**Consultation Response from KC,
Lead Local Flood Authority**
2020/93777 east of, Mill Lane, and Heaton Grange, Hanging Heaton, Batley, WF17 6EN
Outline application for erection of residential development
**Date Responded:
24/12/202**
**Responding Officer:
M J Stephenson**
**Responding Ref:
0**
Summary for Planning Officer

Advisory Note to be Included

Dwn HH	Chkd	Date Oct-20	Scale 1:500@A2	Dwg No. E20/7738/002A
-----------	------	----------------	-------------------	--------------------------

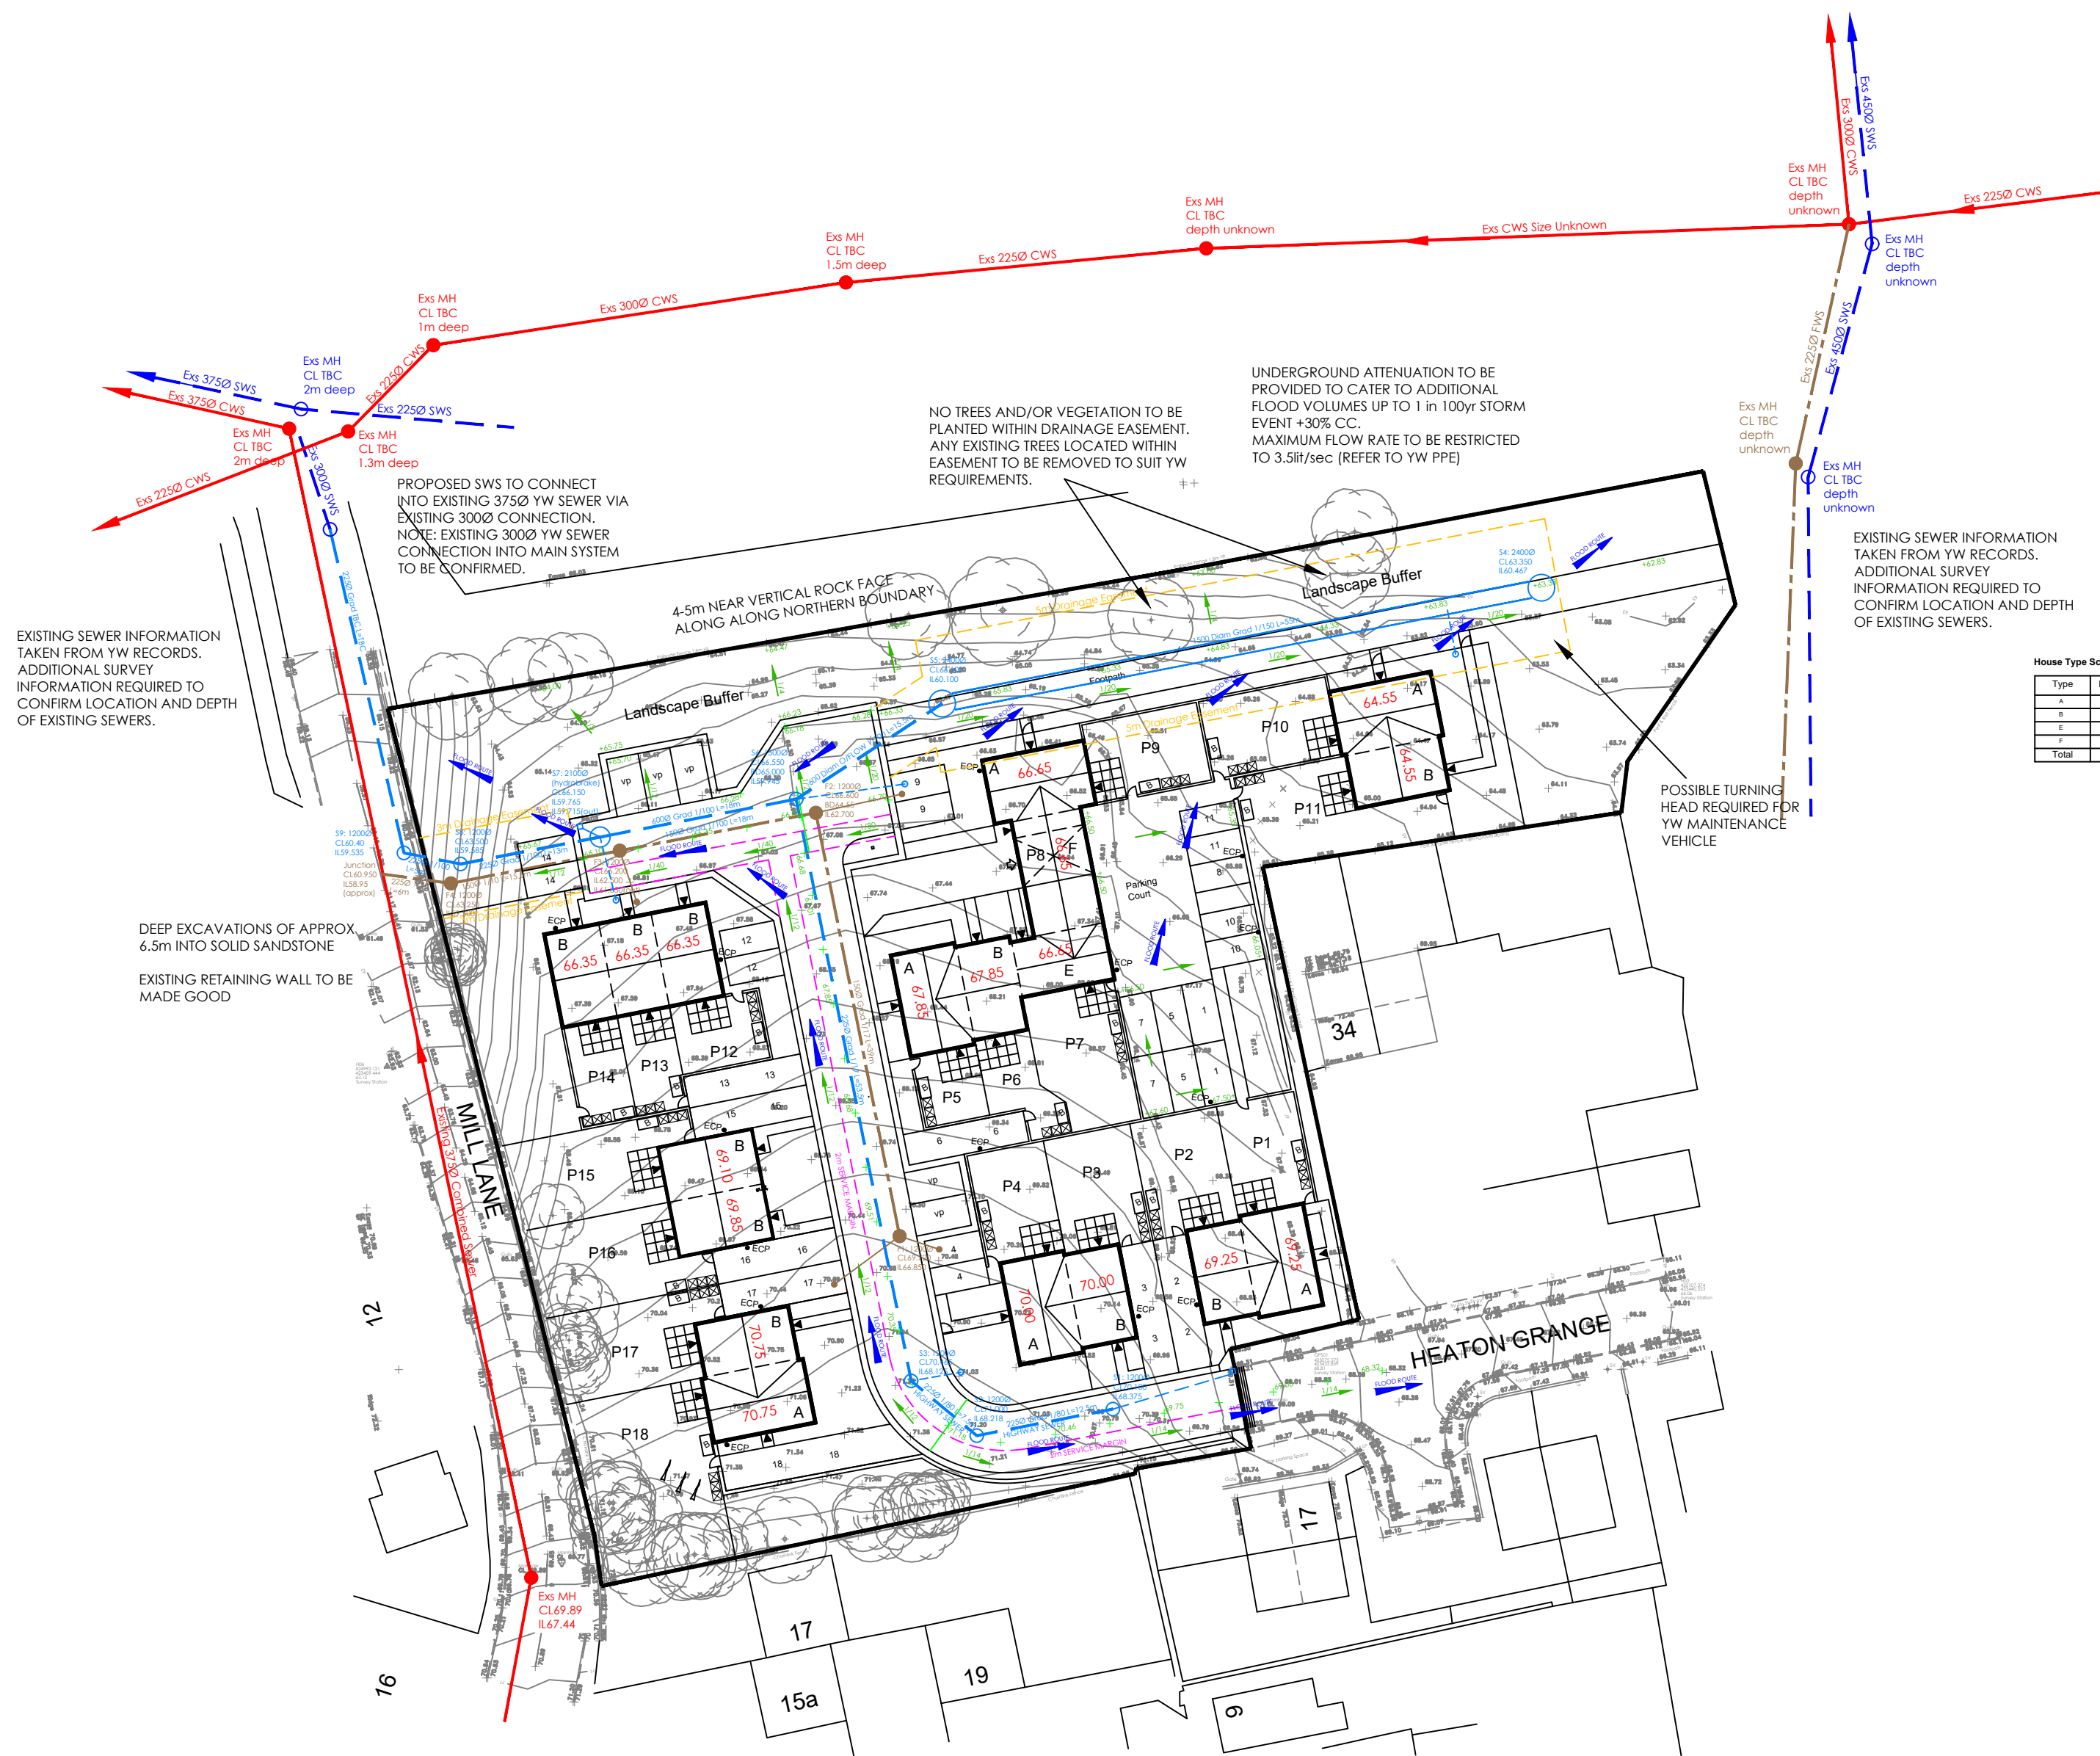
- The flood routing shown on drawing E20/7738/002A indicates that some of the exceedance flows will discharge over the north-eastern boundary of the site into the Batley Business Park and Grange Road Industrial Estate. Measures must be taken to ensure that floodwater does not cause internal flooding, erosion of embankments or blocking of access to any of the existing buildings downstream of the proposed development. Attention is drawn to the guidance given in *CIRIA C635 Designing for Exceedance in Urban Drainage* and it is recommended that the flood routing is compliant with the guidance as far as practicable.

DR07 Overland Flow Routing – Designing for Exceedance

The development shall not commence until an assessment of the effects of 1 in 100 year storm events, with an additional allowance for climate change, exceedance events and blockage scenarios on drainage infrastructure and surface water run-off pre and post development between the development and the surrounding area, in both directions, has been submitted to and approved in writing by the Local Planning Authority. The scheme shall avoid property and curtilage, utilising the road network and open space for exceedance routing. No part of the development shall be brought into use (dwellings shall not be occupied) until the works comprising the approved scheme have been completed and such approved scheme shall be retained thereafter throughout the lifetime of the development.
